THE MEMBER-SECRETARY,
Madras Metropolitan
Development Authority,
No.8, Gandhi-Irwin Road,
Madras-600 008.

A1/19486/92

Sub: MMDA - Planning Permission -

Construction
of residential building in Plot No. 2007pt.
at S.No. 93/1pt. of Madipakkam village -
Approved - Regarding.

PLAN SHOWING THE PROPOSED CONSTRUCTION OF RESIDENTIAL BUILDING IN PLOT NO 2007/PART OF RAM NAGAR NORTH EXTENSION S. NO. 93/5B & 6A OF MADIPAKKAM VILLAGE, SAIDAPET TALUK, CHENGAI M.G.R. DISTRICT.

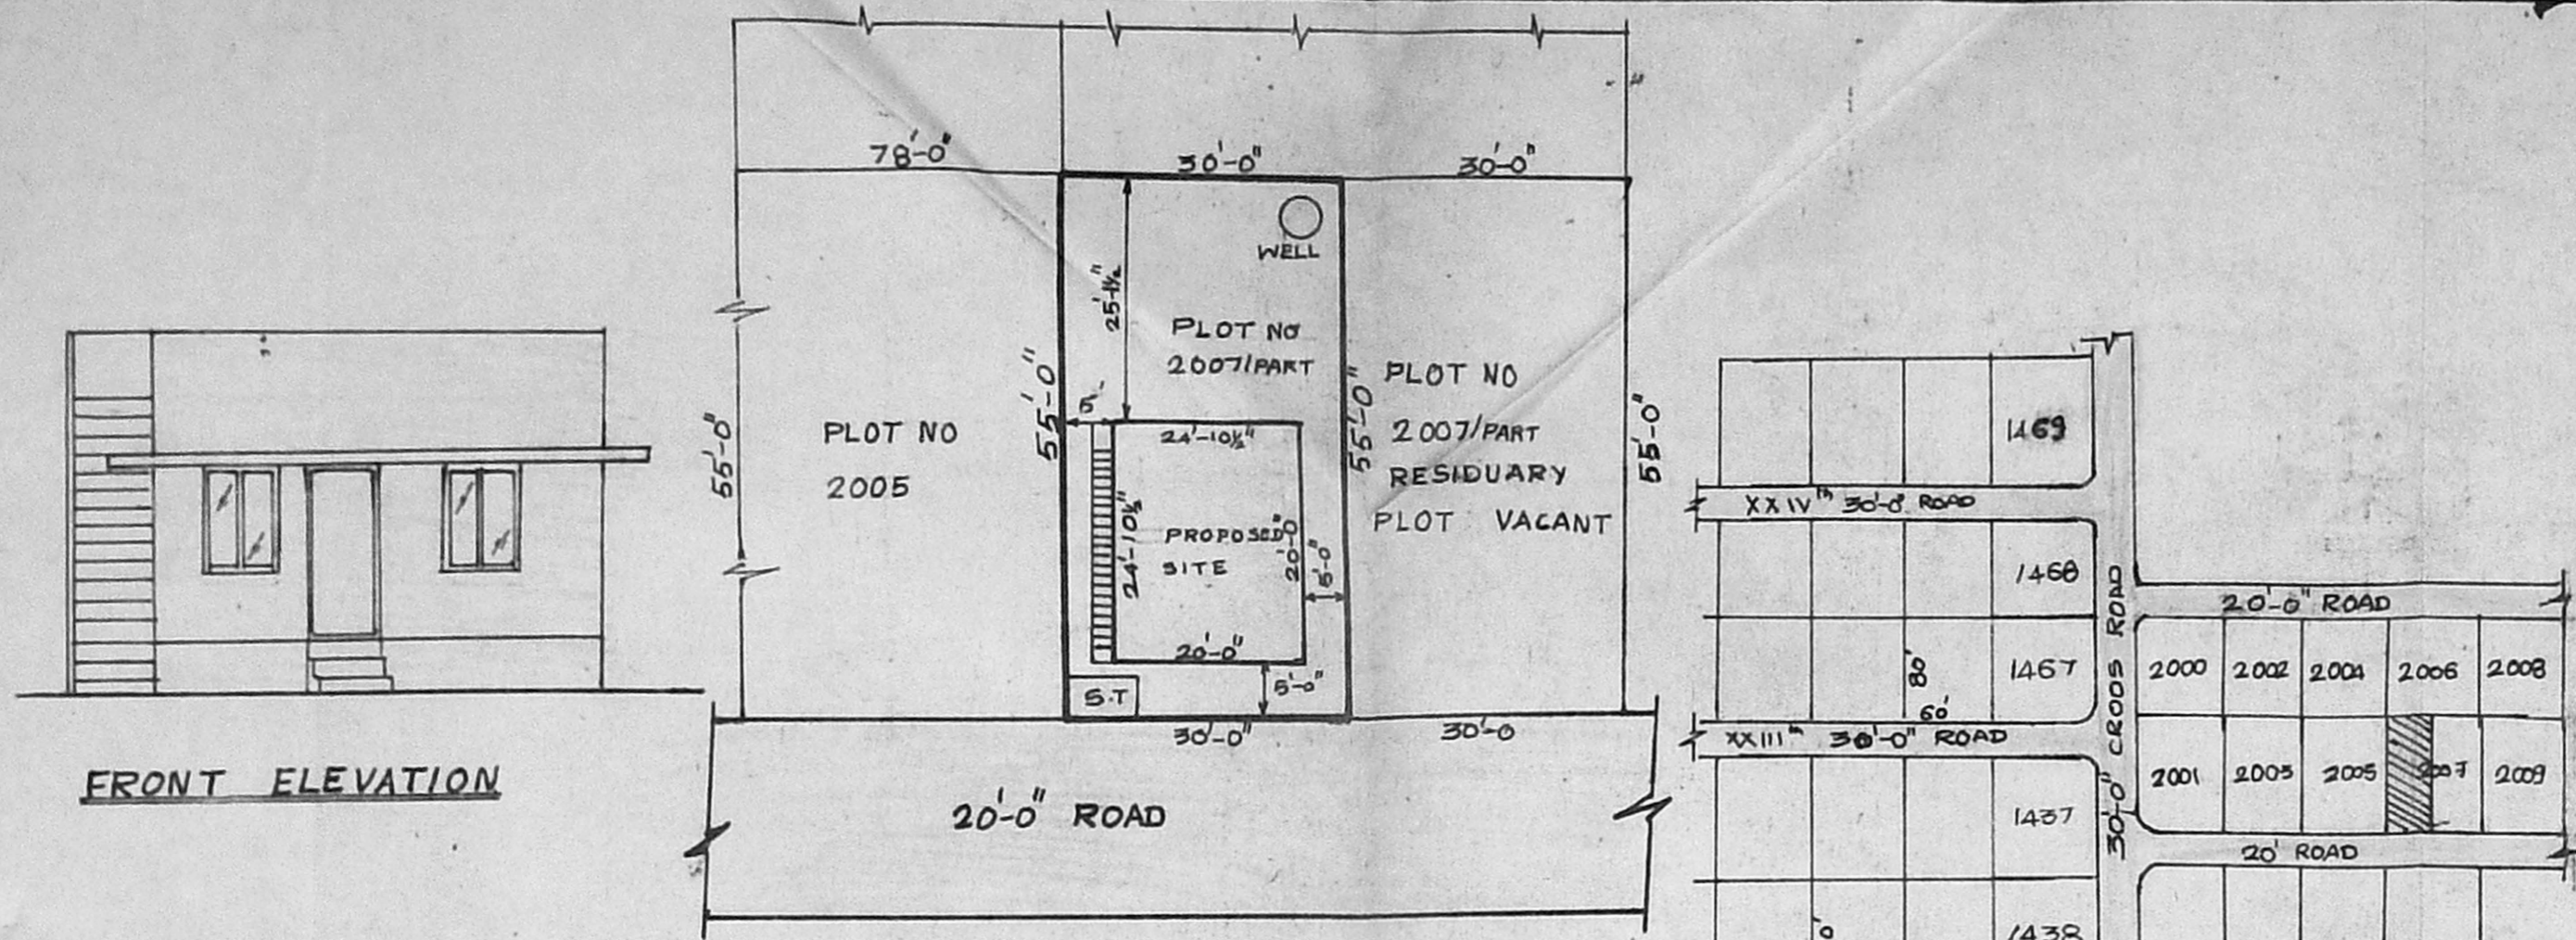
You are requested to furnish
5 copies of revised plan by incorporate the correct Survey No. 10.
93/1pt. 3. On receipt of the amount, the approved plans will
be sent to the
